Land east of Junction 11 of the M40, Banbury

Transport Assessment Update

19th March 2024 SJT\RMcC\23457-11 Transport Assessment Update

3.0 Response to OCC Comments received 12/02/24.

JOB TITLE		LAND AT M40 J11		CLIENT		GREYSTOKE	
DRAWING TITLE							
A361 ROUNDABOUT WITH SECONDARY ACCESS							
SCALE	DRAWN BY	DATE	DRAWING No	REVISION			
1:1000@A1	RM	04/12/23	23457-07-01GA	C

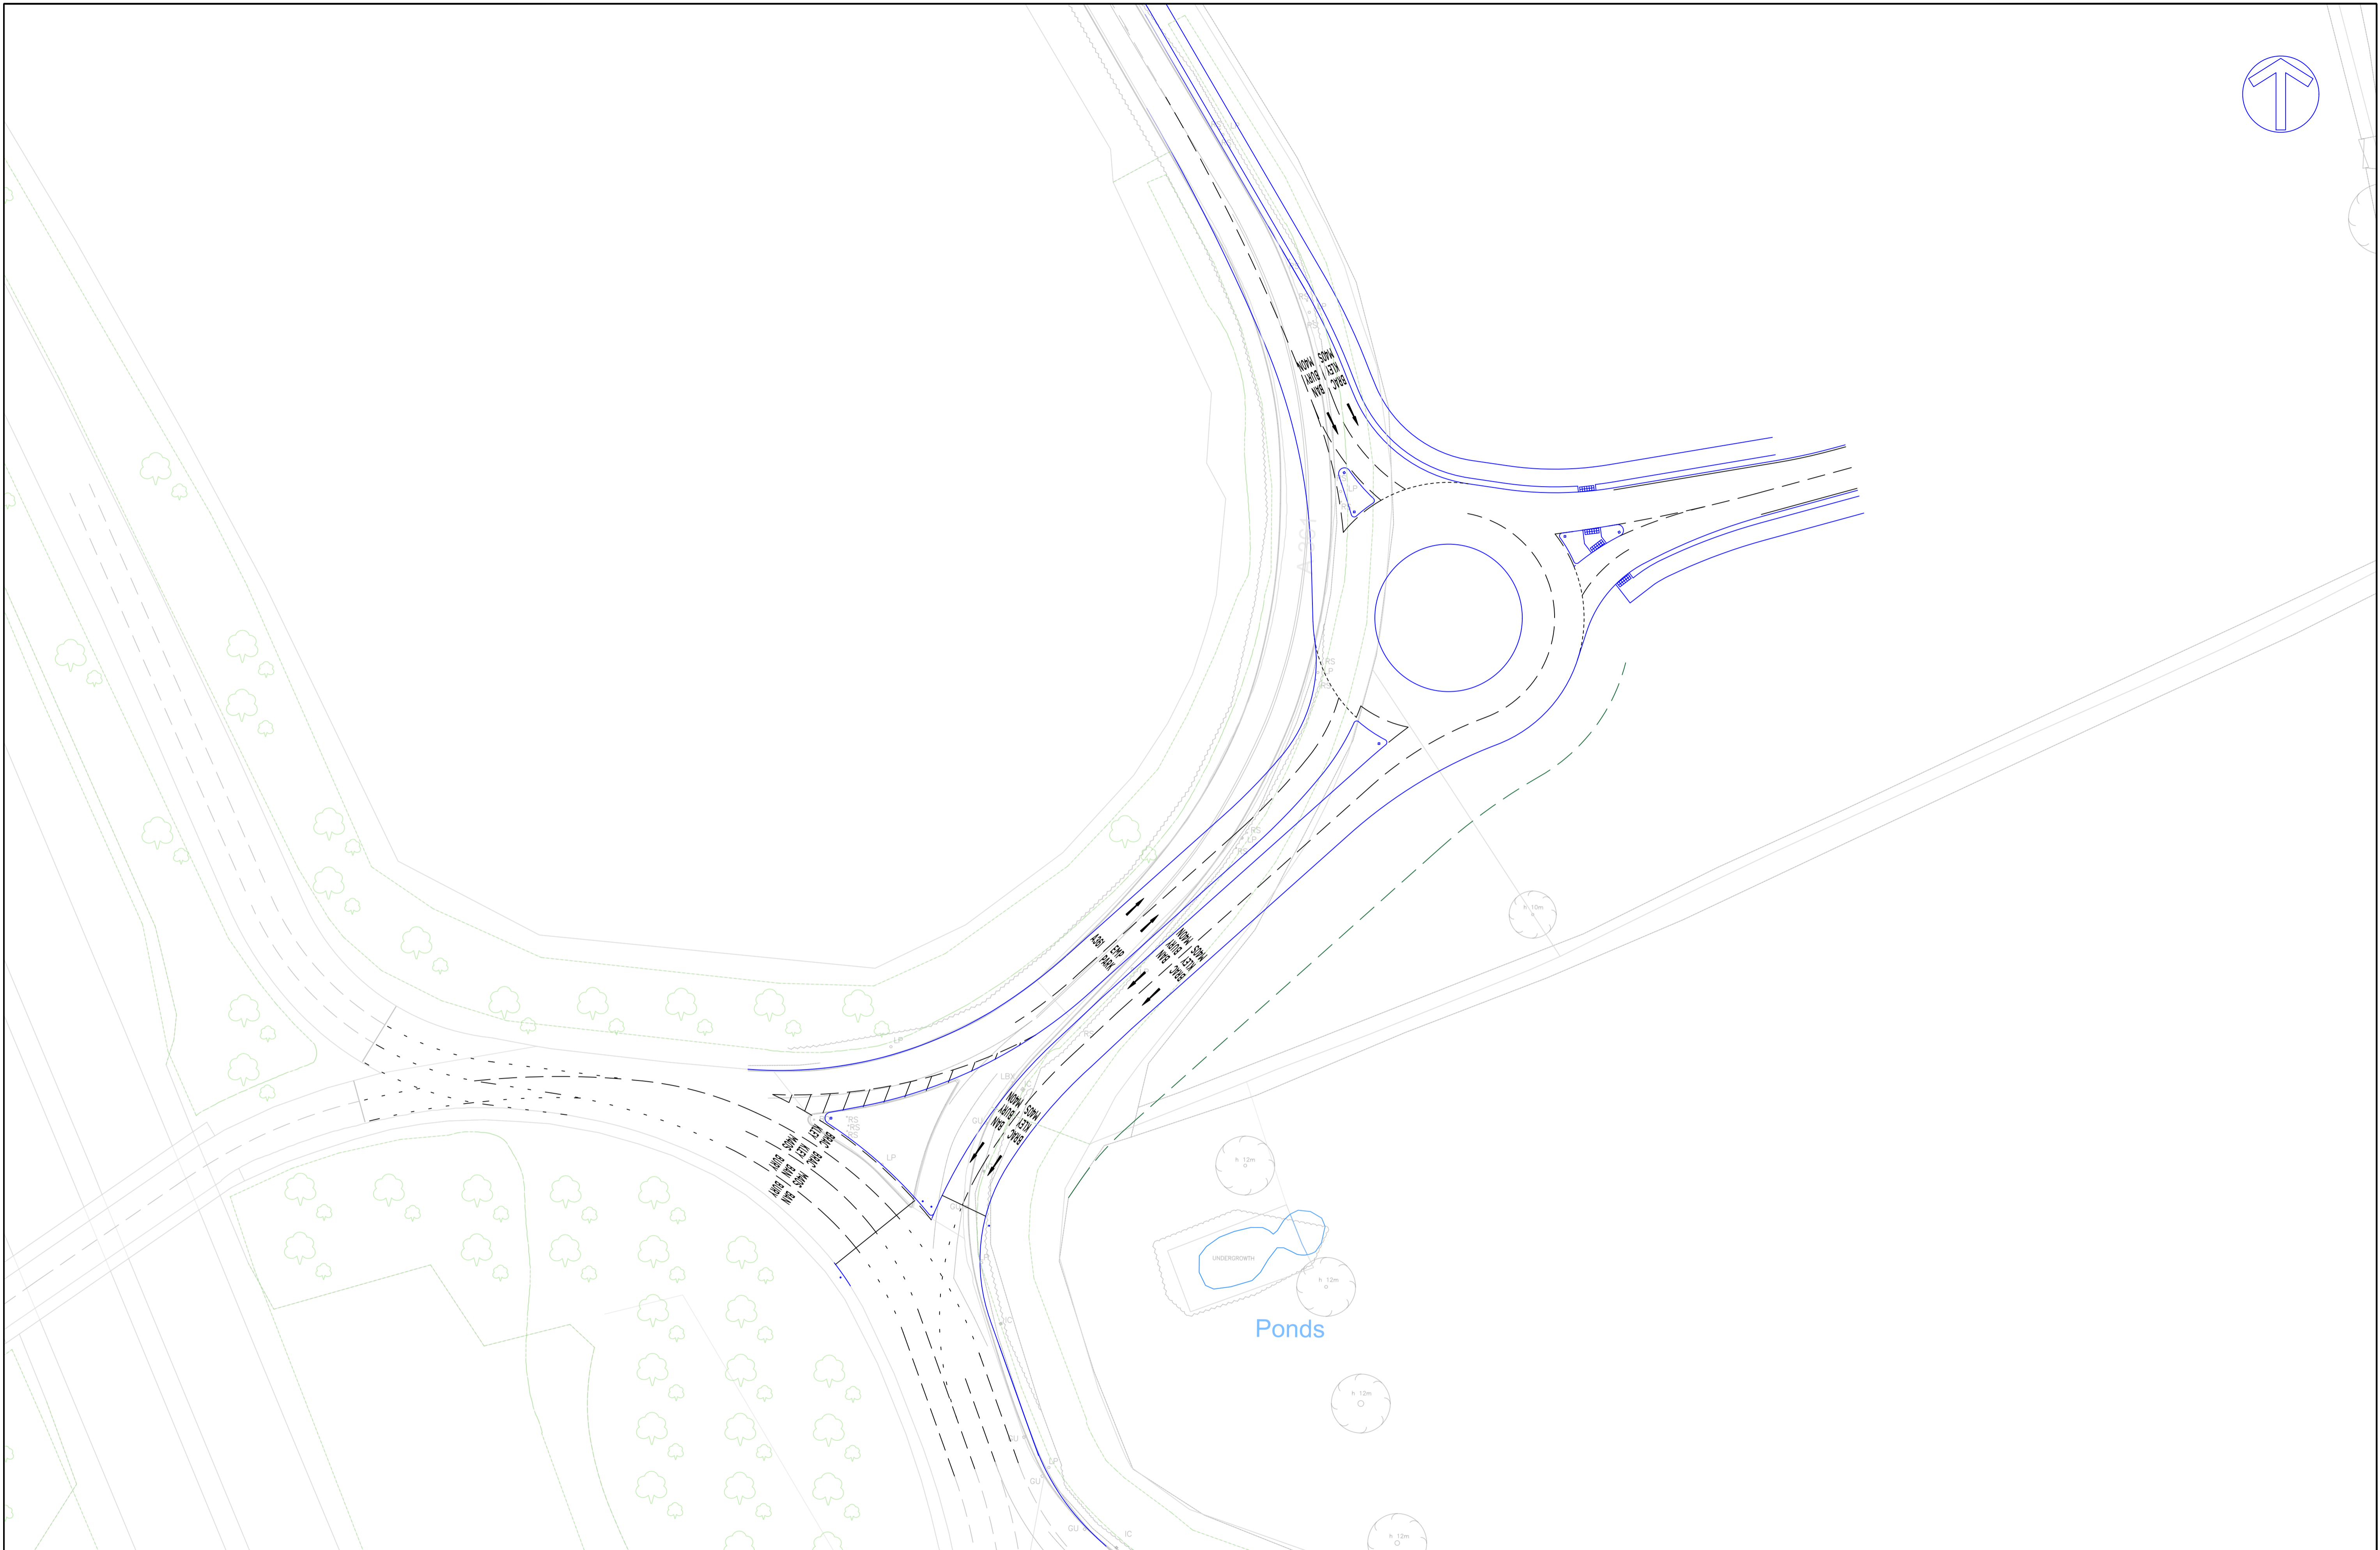
- ii. The proximity of the access roundabout to M40 Junction 11 is likely to lead to severe congestion and potential safety issues arising from queuing on the M40 off slip.

- 3.9 Reason for Refusal 4 relates to a design issue of the site access roundabout and its proximity to M40, Junction 11. The basis for this reason is wholly unclear given that whilst it is raised in summary as an issue by OCC, it is not discussed or identified as an issue in their technical appraisal of the application. Clearly the interaction between the two junctions is a modelling matter and the modelling clearly confirms the interaction will be acceptable. There is therefore no evidential basis for **Reason for Refusal 4**.

- 4.3 The primary vehicle access to the site will be taken from the A361 and will involve the creation of a primary site access roundabout and a secondary standard priority junction.

Figure 2: Signal Mitigation on A361 at Junction 11

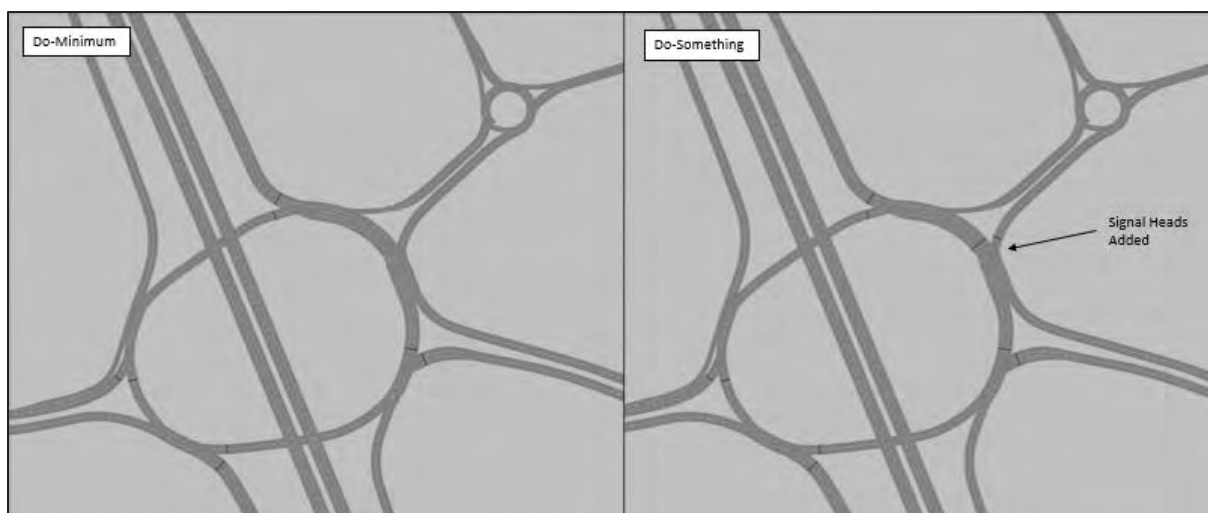
- v. Based on the current modelling results, the proposed signalisation of the A361 does not mitigate the impacts of development.
 - vi. It has not been demonstrated that a signalised crossing of the A361 for pedestrians and cyclists may be incorporated at a safe and suitable location, and an appropriate access into the site is not proposed.

- M40 junction 11 gyratory experiences queuing on the A361 approach in the reference case which will extend back to the site access;
 - A361 queuing is addressed in full by the introduction of traffic signal control on this entry;
